From: Amanda Scholes on behalf of Planning.Responses
Sent: 22 May 2018 08:46
To: Planning Scanning
Subject: FW: Reserved Matter application BN/6/18/RES - The Lillies Former Caravan Park, Yapton Road, Barnham

Please upload the email from ADC Greenspace below onto Ocella as it represents a consultation representation to the submitted revised sketch plan for BN/6/18/RES.

From: Sue Howell
Sent: 17 May 2018 18:14
To: Michael Eastham
Cc: Daniel Vick
Subject: RE: Reserved Matter application BN/6/18/RES - The Lillies Former Caravan Park, Yapton Road, Barnham

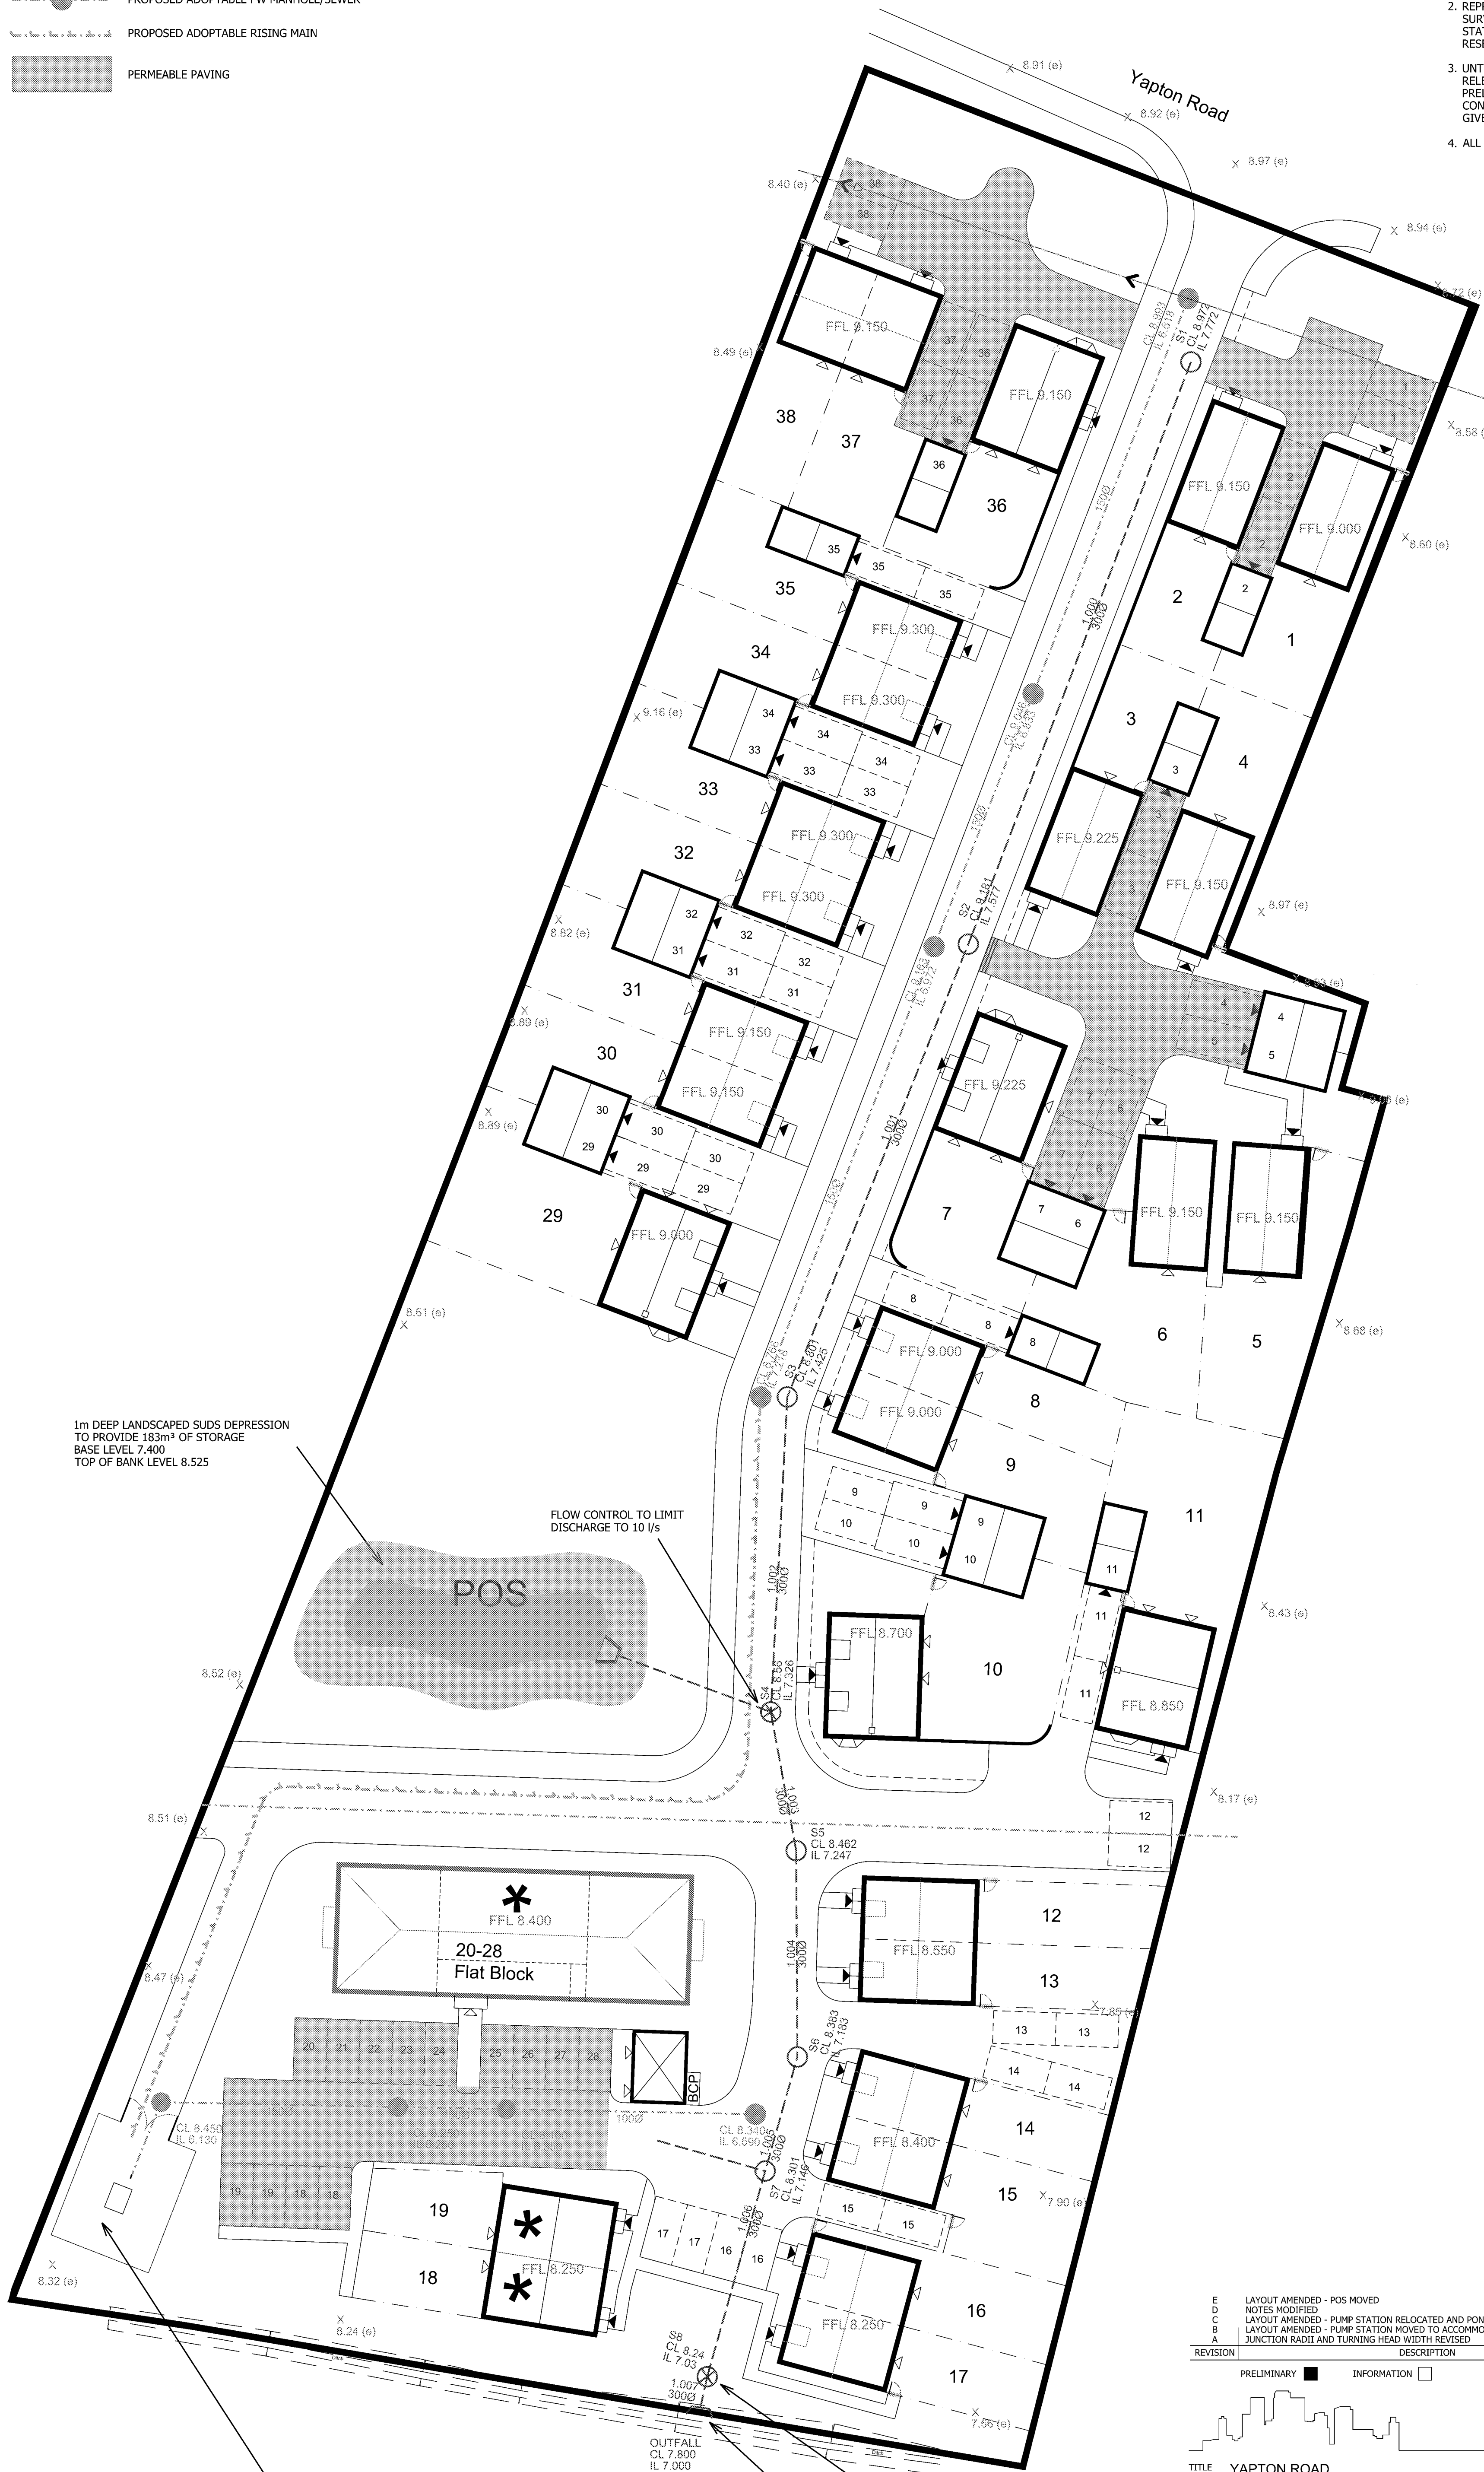
Whilst I can concur that there has been a gradual improvement in what has been offered during this process and particular improvements in certain areas more than others. The layout now to move the POS back more centrally within the development being the primary one and also the setting back of the dwellings from the road frontage and greening surround to the apartment block improving aesthetics and privacy for these residents. Conversely the SuDS still proposed within the deficient POS main area has not been addressed and the resulting inadequate provision still remains.

The issue remains that the central and proposed POS being provided when viewed in conjunction with the SuDS scheme and what would then be usable and well-designed POS area is still deficient.

The figures for comparison with the Outline total POS and that now contained within the RMA sketch is in principal an improvement in layout, but does not meet the requirement of our SPG or GEN7. I do not agree that the area now included within the figures for the opportunity of an area of POS measuring 275m² alongside the apartment block as being usable by anyone would in practice be used as such and would not be a positive addition in terms of accessible, usable and well-designed POS, being in reality and extended grass verge area not an area for play or recreation. Yes a positive addition in greening and for the privacy of the residents of the apartment block but not considered sufficient in size to provide meaningful well designed usable open space for calculation purposes.

In view of the above I would still have to recommend my objection to the RMA sketch plans relating to good design and lack of Open Space provision with this proposal.
